Application Reference: 6/2017/0430/LAWE
Proposed Development at: 8 Carbone Hill, Northaw, Potters Bar, EN6 4PL
Proposal: Certificate of lawfulness for existing outbuilding to be
ancillary to the existing dwelling

AMENDMENTS TO APPLICATION dated 17 March 2017

North Elevation

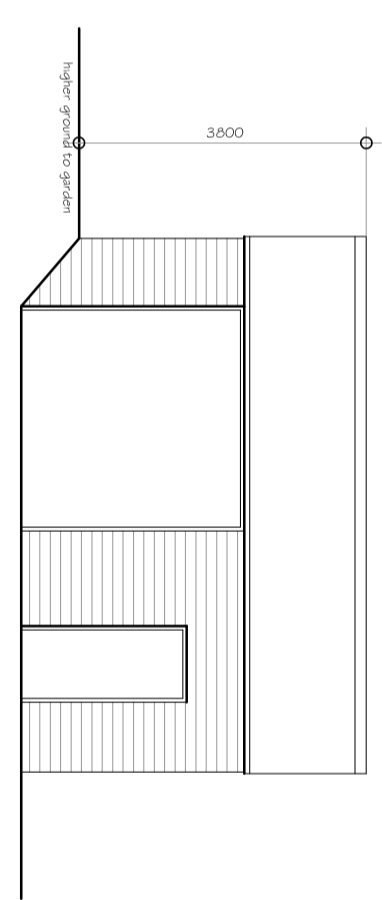
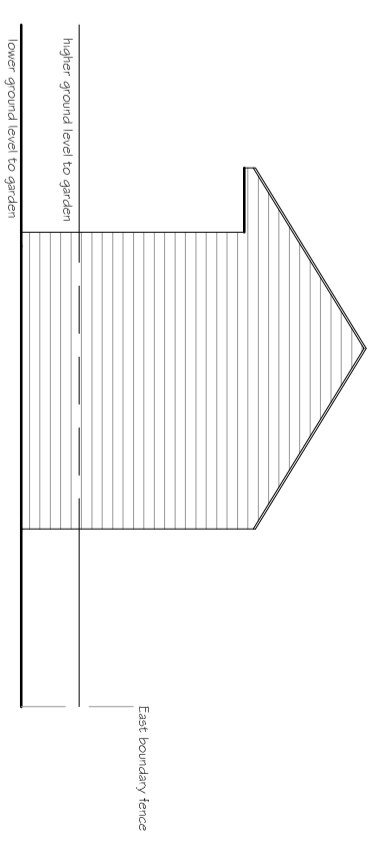
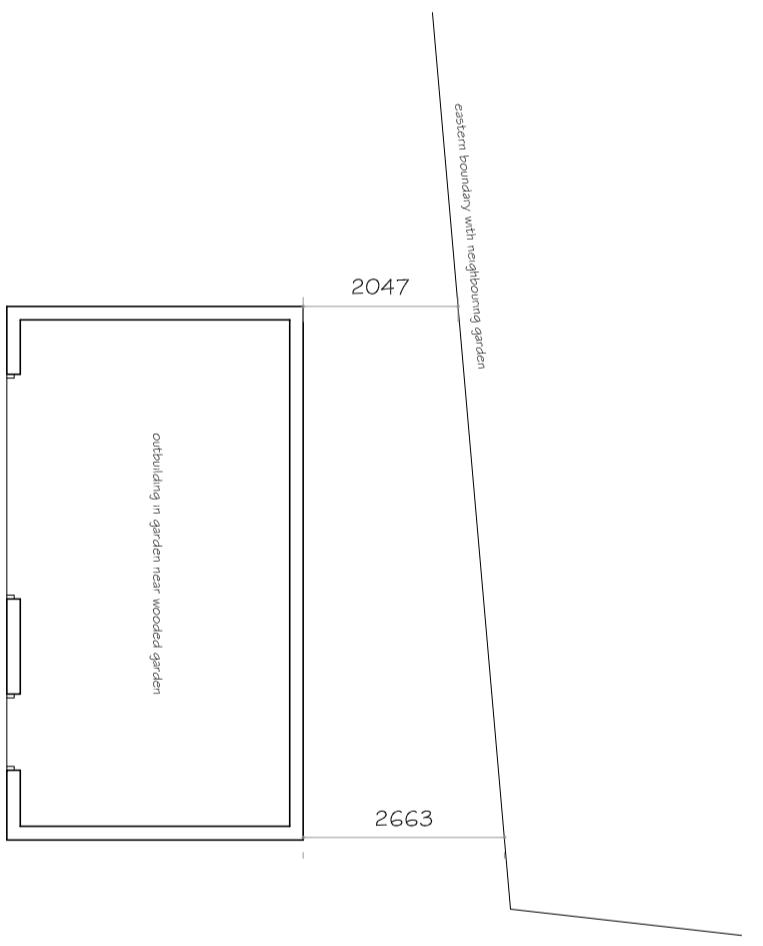
Box at the end of Section 9. We understand that planning regulations say that the height of a dual-pitched roofed outbuilding, standing at least two metres from a boundary fence, should be no more than four metres to the ridge. Within the past months the ground at the west end of this outbuilding has been heaped up and the earth tamped.

Measuring from the top of this, the actual height has been significantly reduced. However, regulations further state that the measurements should be taken from "the original ground level". From here, the height is clearly more than four metres.

Similarly, planning regulations limit the allowable wall height up to the eaves. This is 2.5 metres for a dual-pitched roofed building. Taken from the top of the piled-up earth, the wall up to the eaves is around 3 metres. Measuring from the original ground level, as regulations state, it is significantly more than this.
